Application number: 2020/94086	
What is the application for?:	Erection of raised decking to front
Address of the site or building:	42, Britannia road, Milnsbridge, Huddersfield, HD3 4QF
Postcode:	HD3 4QF

AS BUILT SURVEY DRAWING

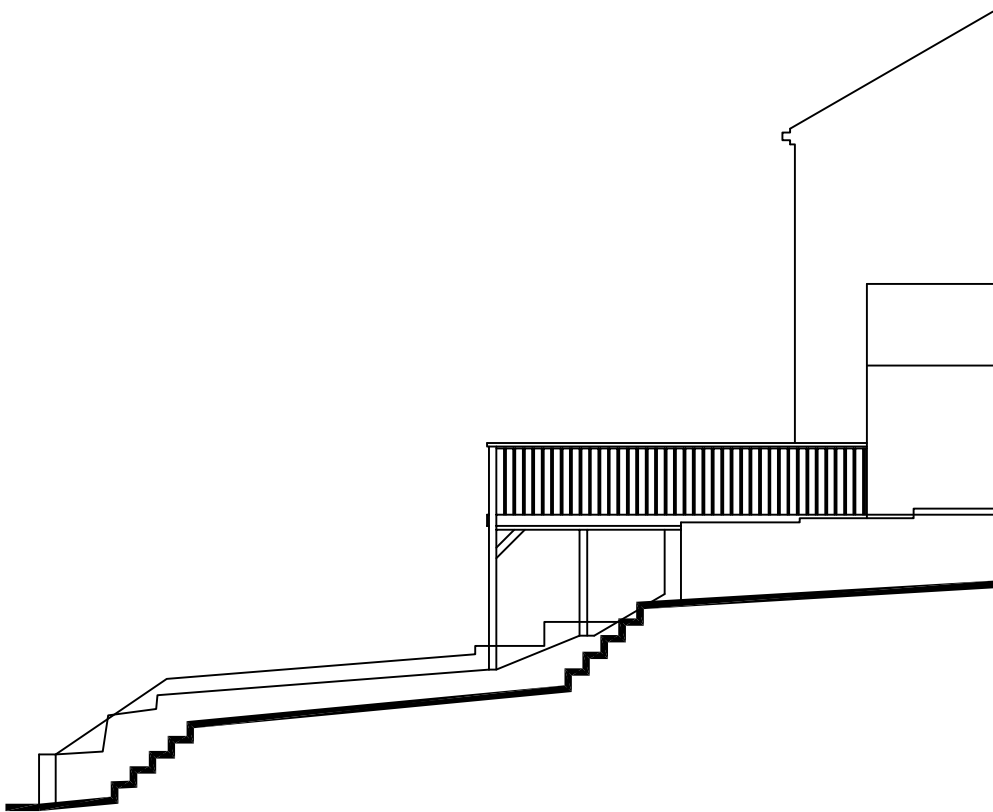
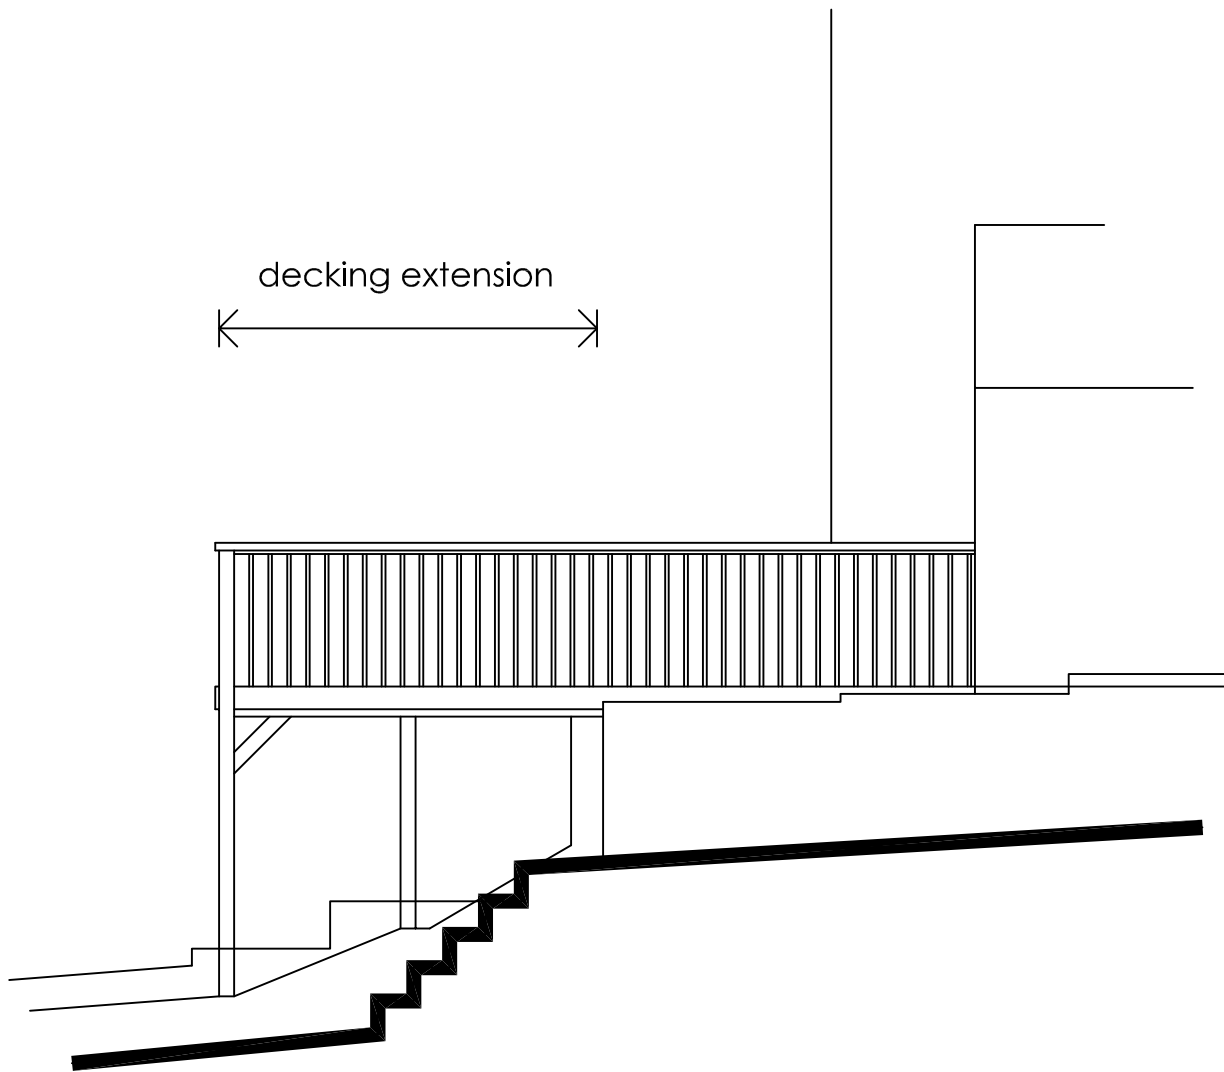
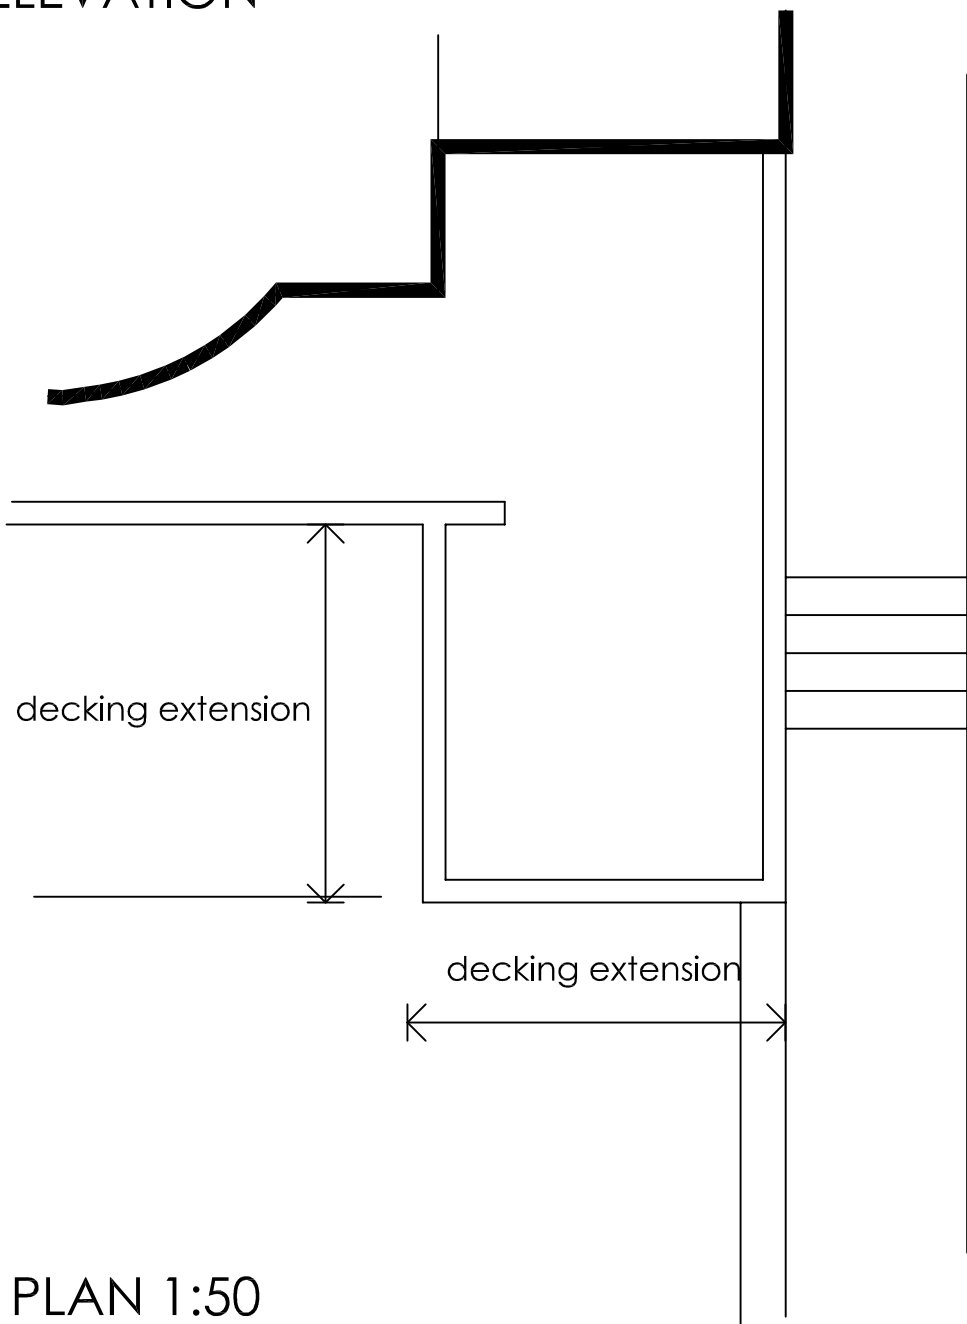
Type of comment: An objection	
Do you wish your comments to be published on the website anonymously?	Yes
This already erected structure blocks light to my property and allows people on this raised deck to look straight into my house, separately it is poorly constructed sat on top of an existing wall of questionable structural integrity
